11 February 2019

RMS Reference: SYD17/01618/03, SYD12/00236/10, SYD12/00236/11, SYD12/00236/12
DPE Ref: SSD 5175 MOD 4, SSD 5175 MOD 5, SSD 5175 MOD 6 and SSD 8588 MOD 2

**MODIFICATION TO THE EASTERN CREEK BUSINESS HUB
ROOTY HILL ROAD SOUTH, ROOTY HILL**

Figure 11: Vehicle access

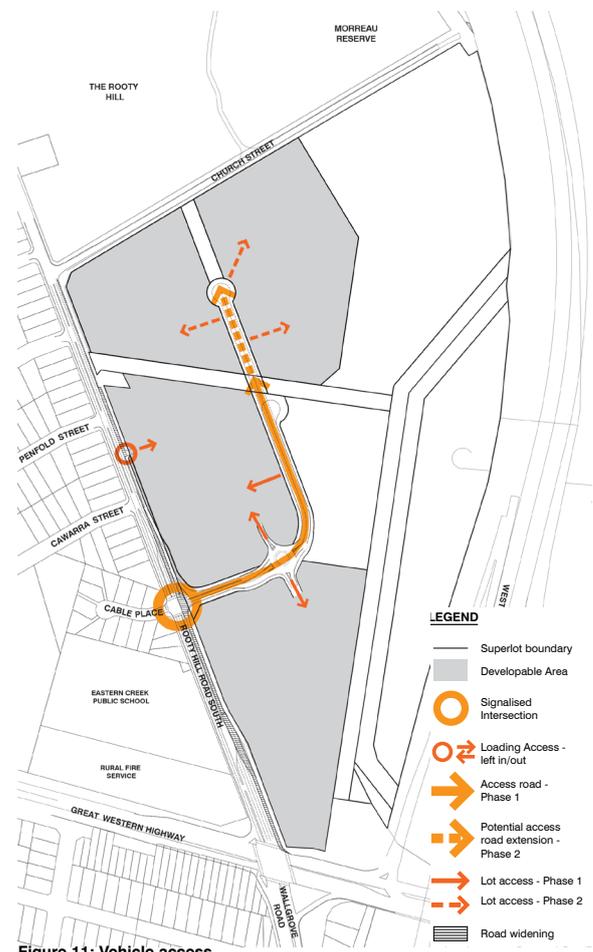
Roads and Maritime have concerns regarding the location of the proposed roundabout in relation to the signalised intersection of Rooty Hill Road South and Cable Place. The provided traffic report states that the 95 percentage back of queue on the spine road does not extend back through the roundabout. However the submitted traffic modelling indicates that the westbound right turn movements have a 95 percentage back of queue length of 117.7 metres which could result in queues through the proposed roundabout.

Roads and Maritime is concerned that because the roundabout is located only 100 metres east of the signalised intersection on Rooty Hill Road South, the queues through the roundabout will likely result in the roundabout functioning inefficiently, and in turn negatively impacting the signalised intersection.

1. Amended plans which relocate the proposed roundabout further to the east, clear of the westbound right turn queue. The relocation is to be supported by an amended Traffic Report.
2. An updated SIDRA Model needs to be submitted to ensure that the relocated roundabout can accommodate projected traffic volumes that will be generated from the proposed development (and any known adjoining developments). Also the signalised intersection on Rooty Hill Road South needs to perform at an acceptable level of service.
